Application for a Non-Material Amendment Following a Grant of Planning Permission

An application submitted under Section 73 of the Town & Country Planning Act 1990 for a minor material amendment to change: the side elevation by projecting one part and setting back the part of the elevation; the fenestration to the front elevation, rear and side; approved materials to front from bricks to bricks and rendered; replacement of entrance door with introduction of a curved feature; and installation of two rooflights, submitted in connection with the planning permission DC/20/116546 dated 26 June 2020 for 'The Construction of part one/part two storey for bedroom dwelling house adjacent to 30 Ravensbourne park SE6 together with an extension to the existing vehicular crossover

DC/21/124478

Replacing two windows on the ground floor side elevation with one window with the same width

Drawing No.  
2101-NG02  
Drawing Title:  
granted and proposed change  
in Ground Floor  
Scale:  
1:100 @ A3

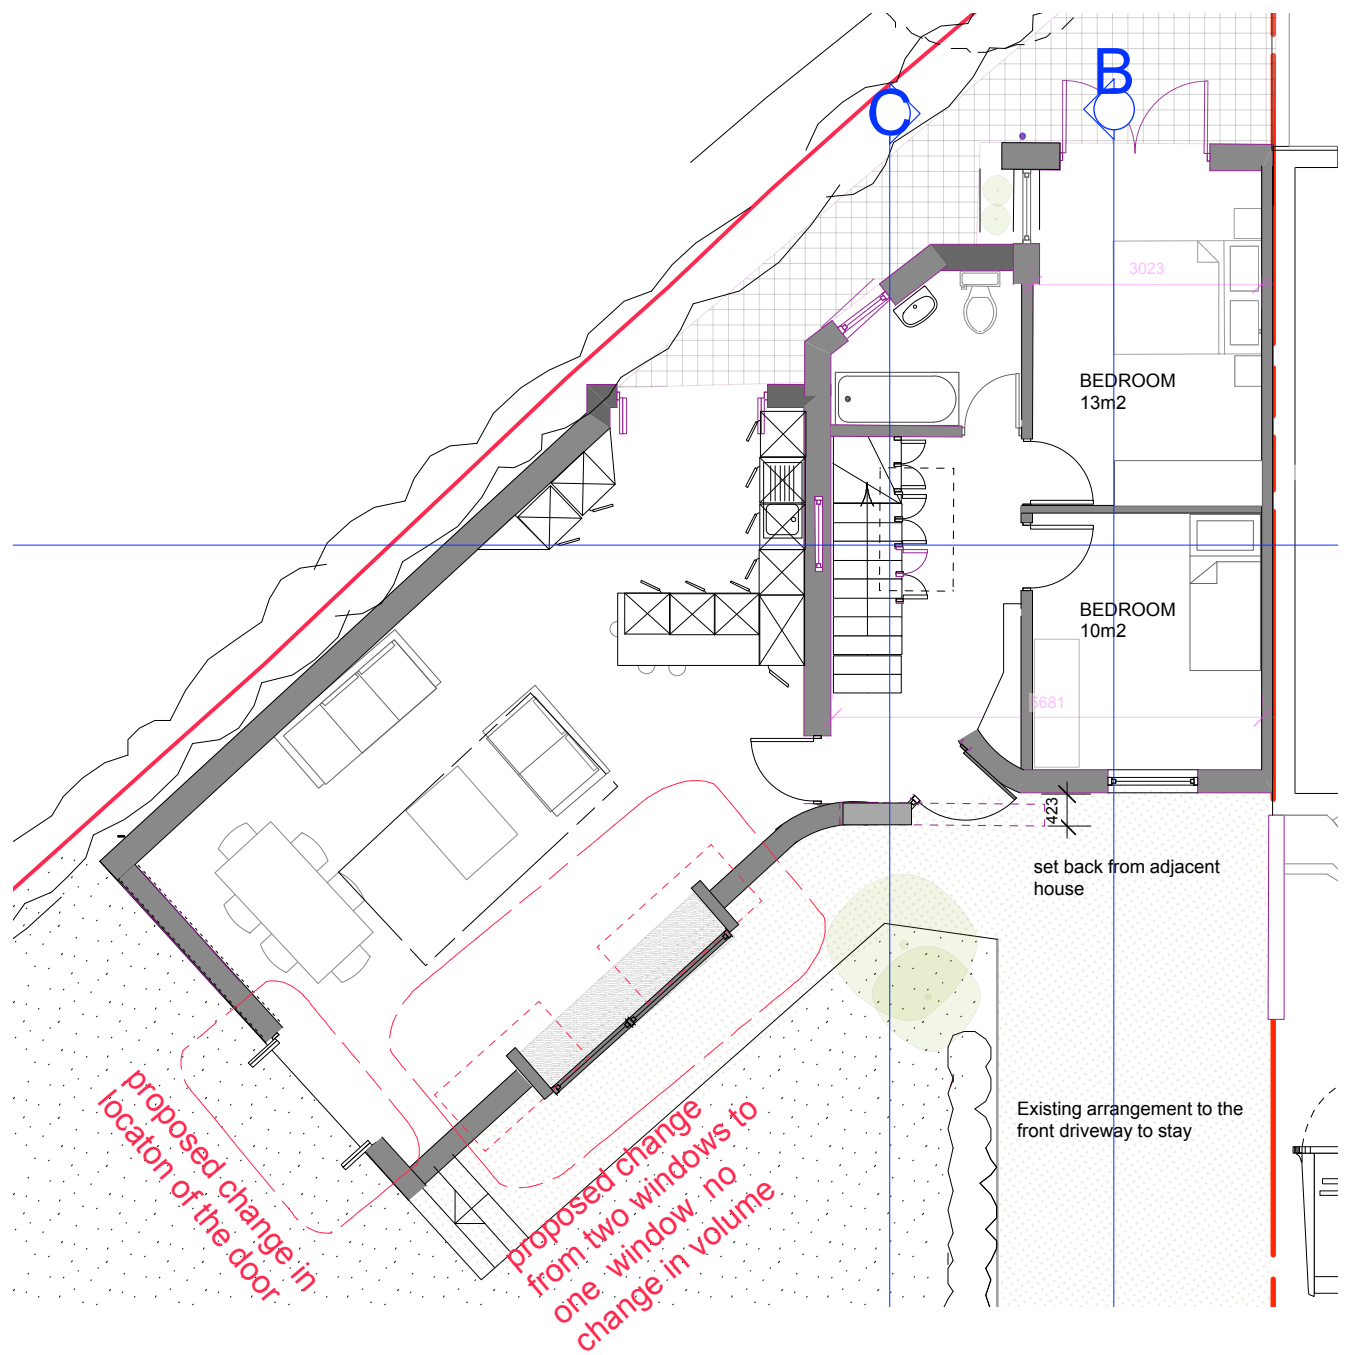
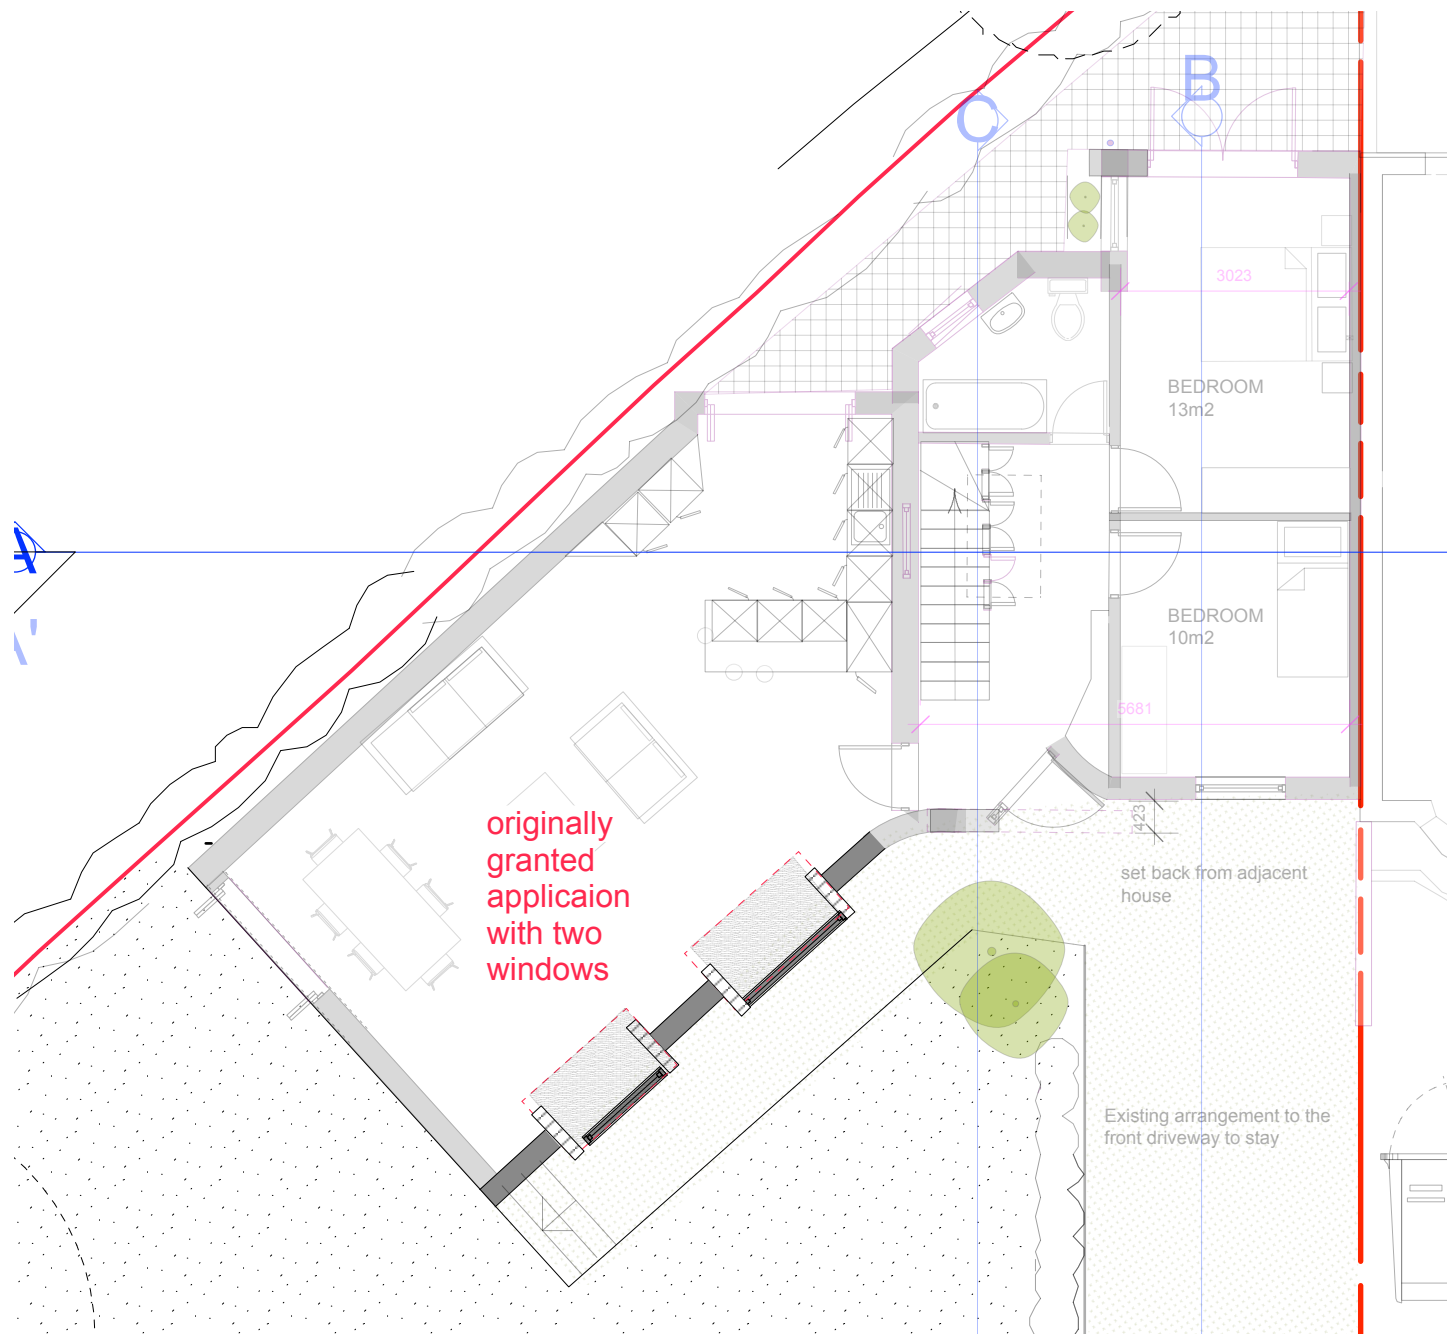
The building is near completion, the non material amendment is related to a side elevation on the ground floor where two adjacent windows are joint to become one window (same joint width). This has no impact on volume or footprint or the Main Street elevation as the change is minor and does not show on the main elevation as it is covered behind a green fence that is part of the main garden. (see elevation for further details)

The reason behind this is structural stability as the joint between the two windows was weak, hence joining them was more feasible. but also a better aesthetic quality as less joints are proposed . it allows for a better lighting and use of the space without any impact on the character or the main features of the development
